# Norfolk Boreas Offshore Wind Farm Joint Position Statement with North Norfolk District Council Noise Sensitive Receptors

Applicant: Norfolk Boreas Limited  
Document Reference: ExA.AS-5.D6.V1  
Deadline 6

Date: March 2020  
Revision: Version 1  
Author: Royal HaskoningDHV

Royal HaskoningDHV
Enhancing Society Together

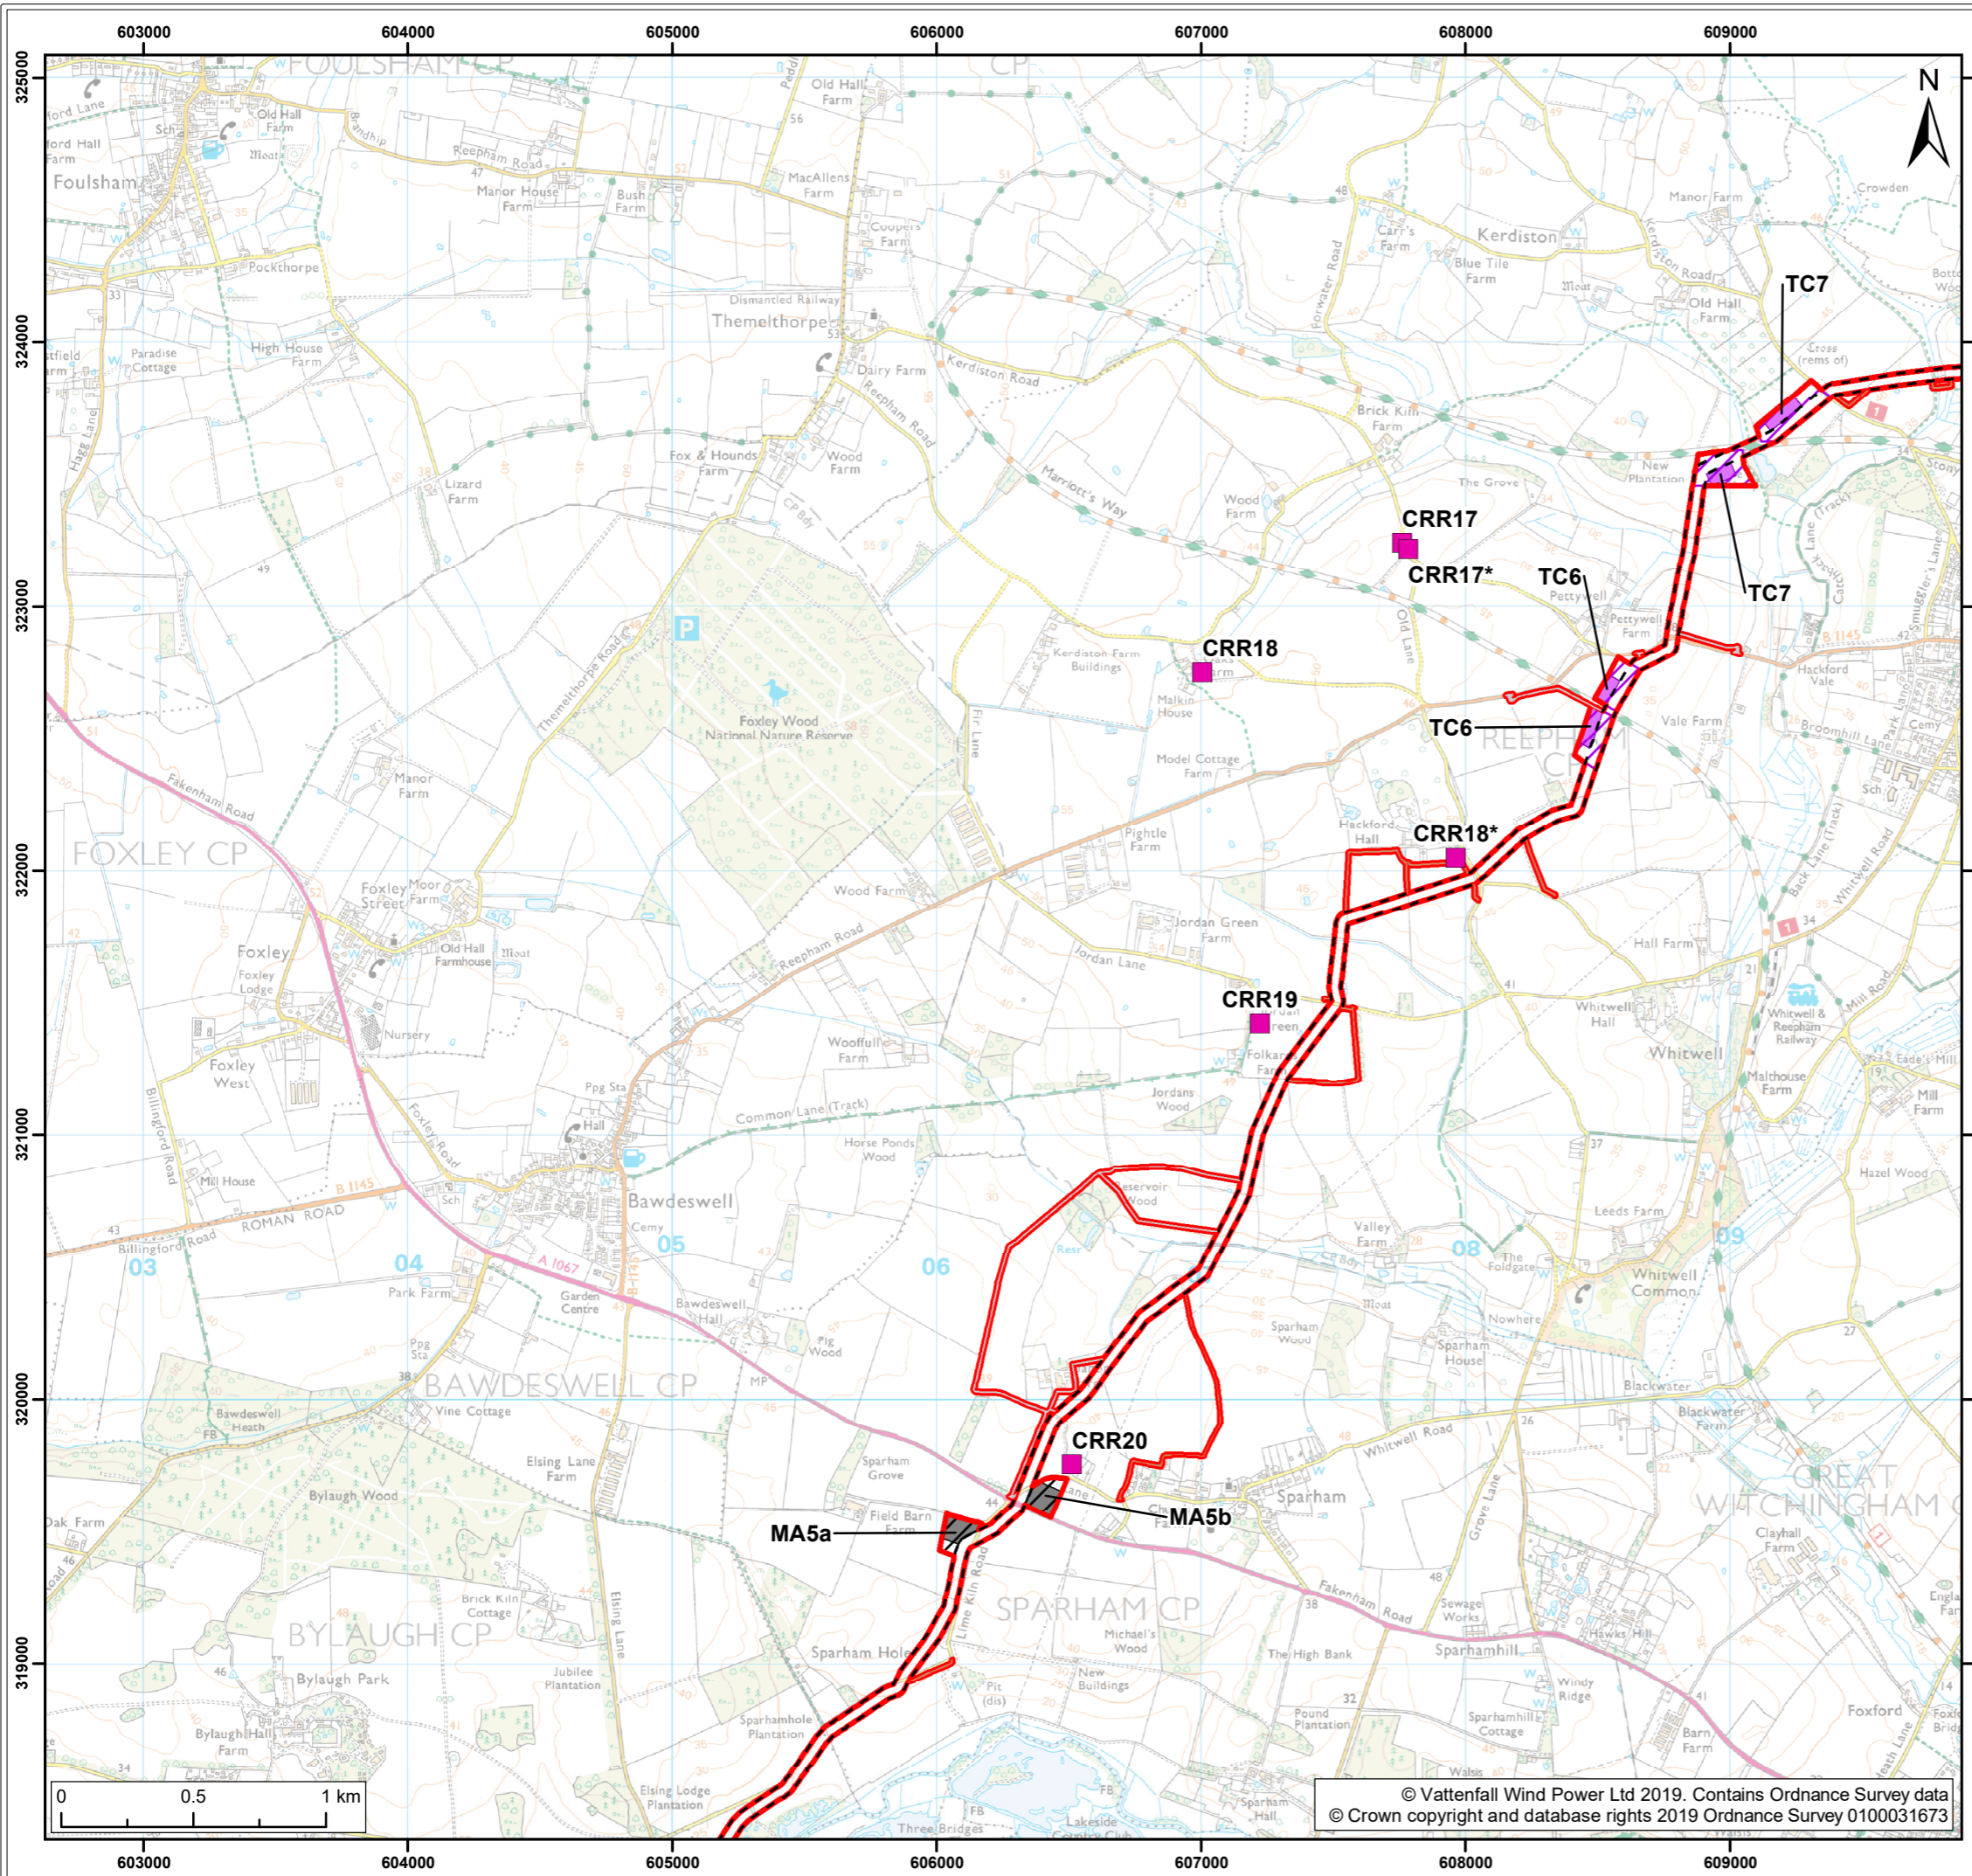
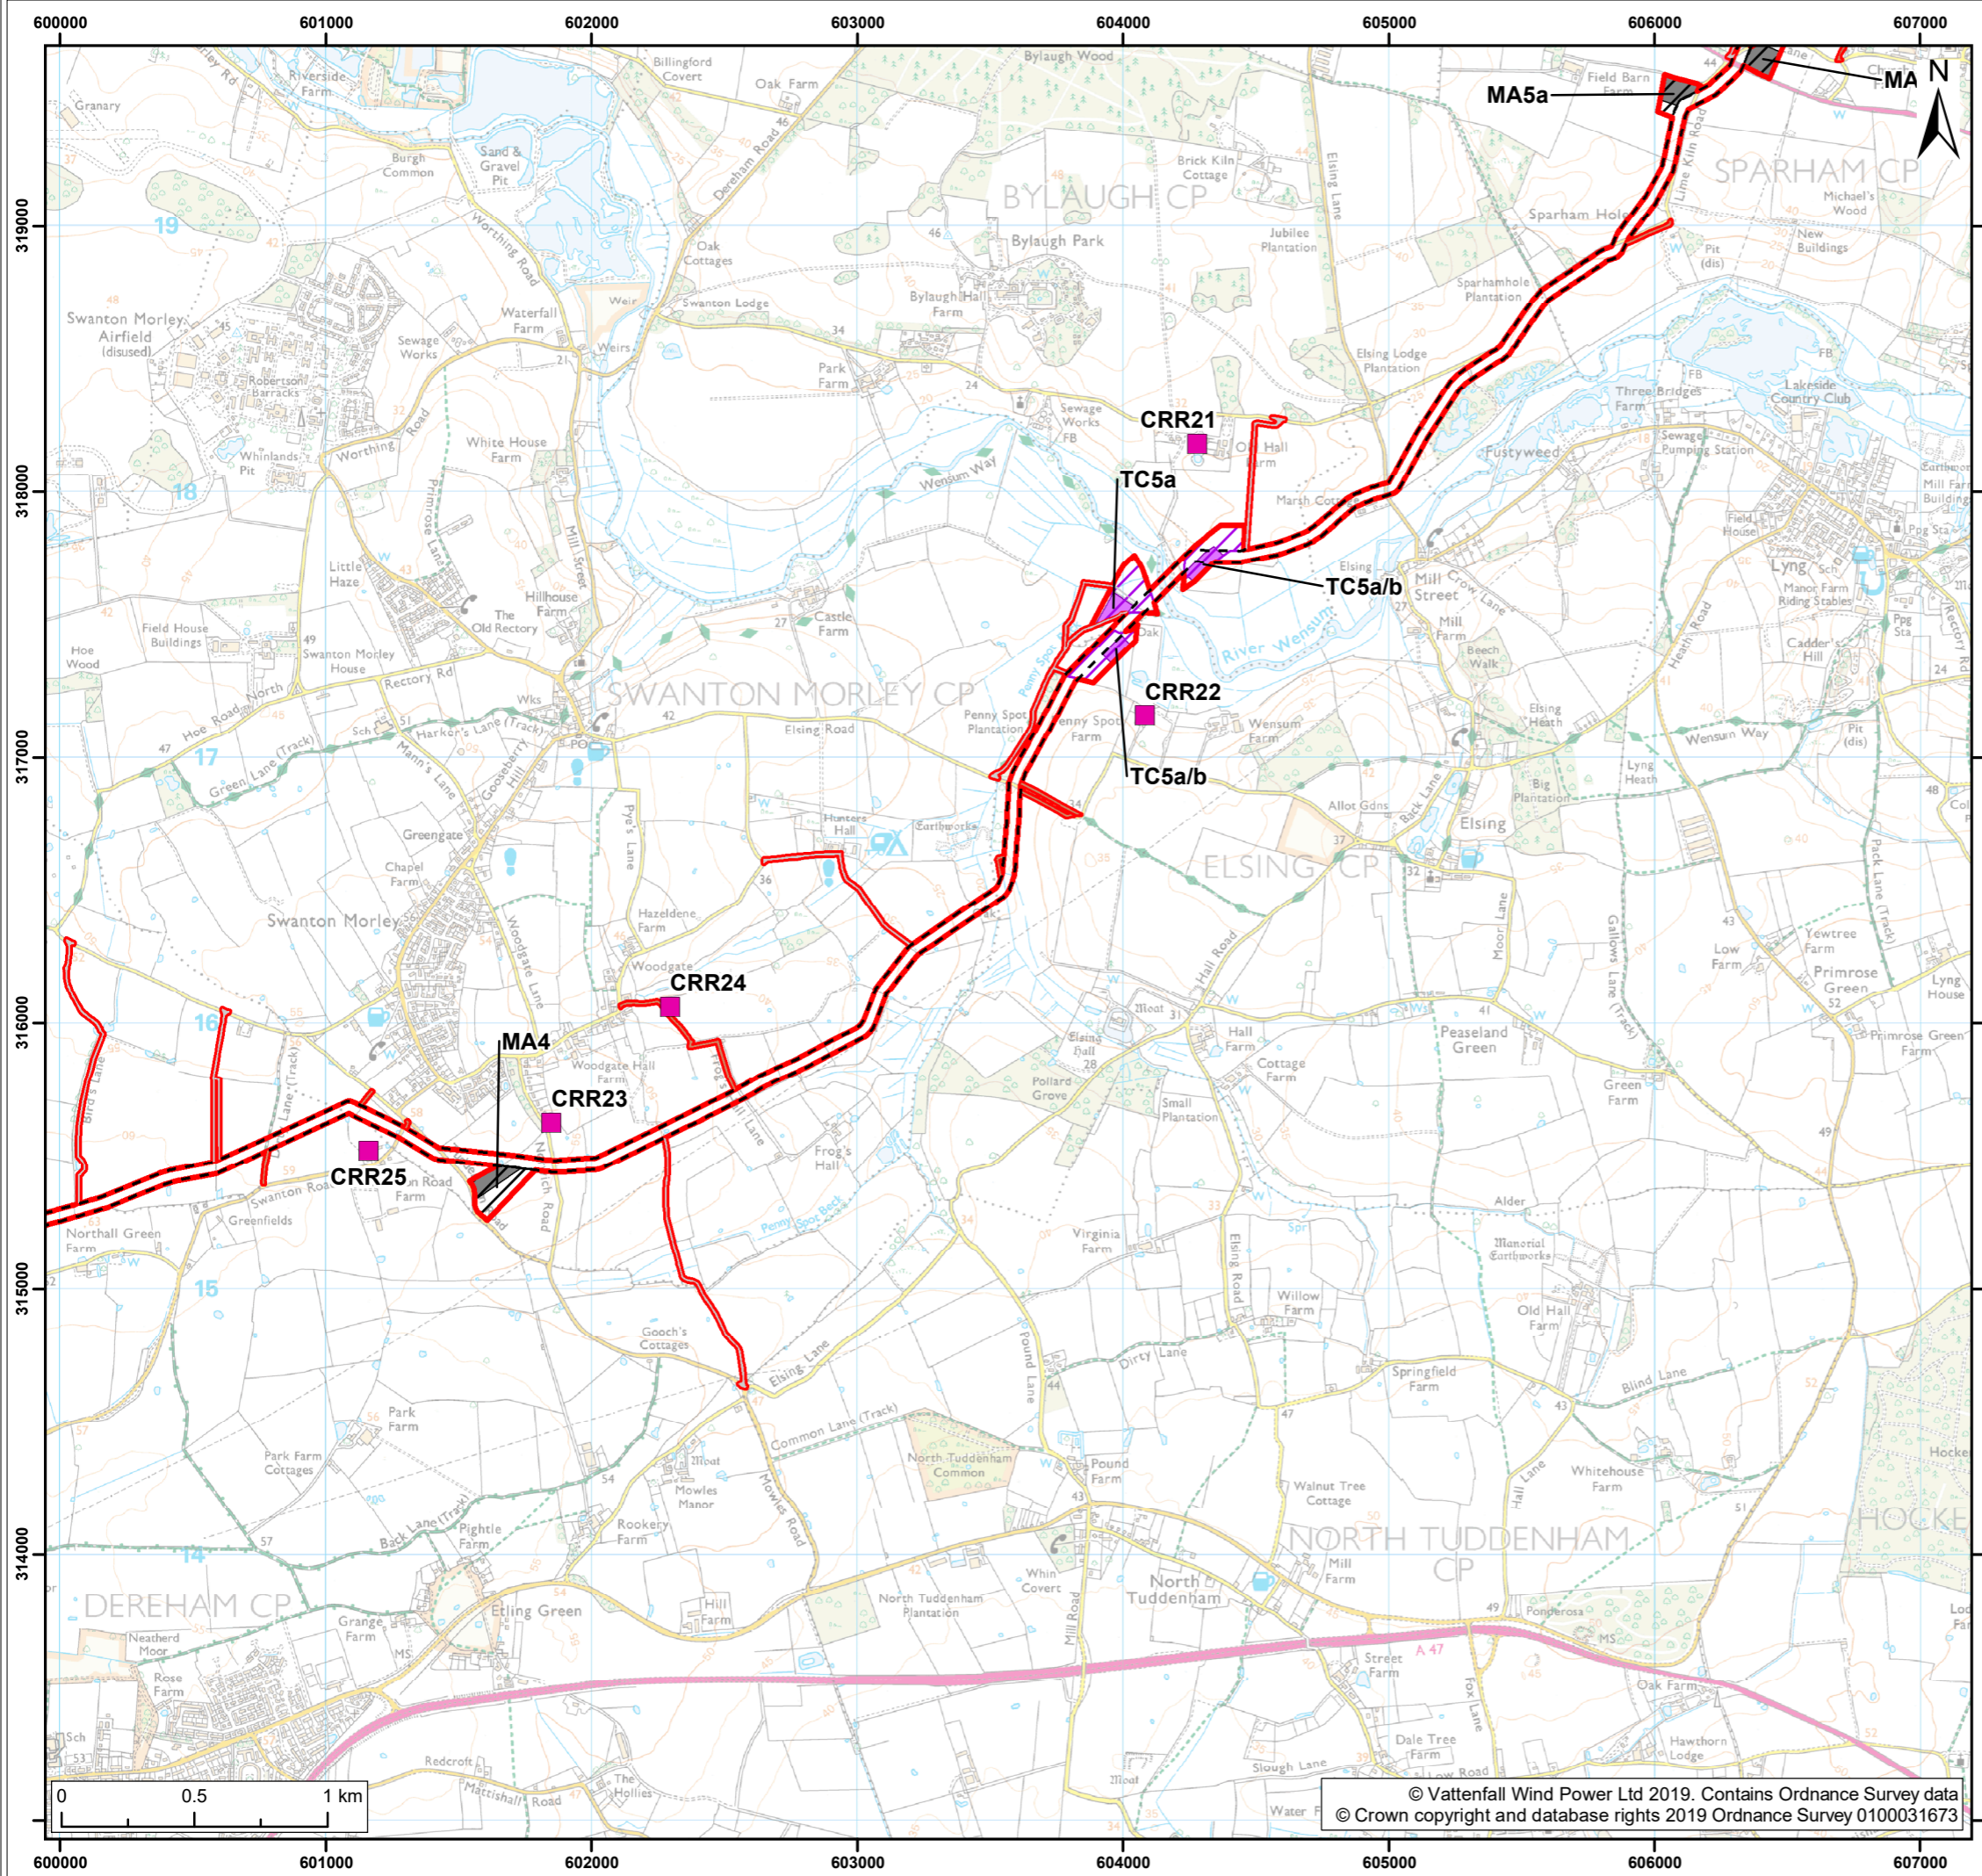
21. In terms of the locations set out above at paragraph 14 a) and b), whilst NNDC note these examples, the locations of which are set out in document 6.2.25.2 Environmental Statement - Figure 25.2 Noise Receptor Locations [APP-470], it would be helpful and clearer to all parties if these locations are also described by their address location (e.g. road name and village) and/or add map references.

- 3) In Table 1 Cycle routes to be identified as low sensitivity receptors rather than negligible.
  - 4) For the receptor locations identified as potentially requiring enhanced mitigation (in section 3.1) to also be described by their address location (e.g. road name and village) and/or add map references.

- ii. Provide additional detail on the receptor locations requiring enhanced mitigation to include road name and village and a map reference;
  - iii. Include additional text (as per Section 3.2) to confirm that the development of the CNMP will include a review of the construction activities and the identification of any potential noise sensitive receptors (as defined in Table 1) which may be affected and identify any potential control to minimise effects.
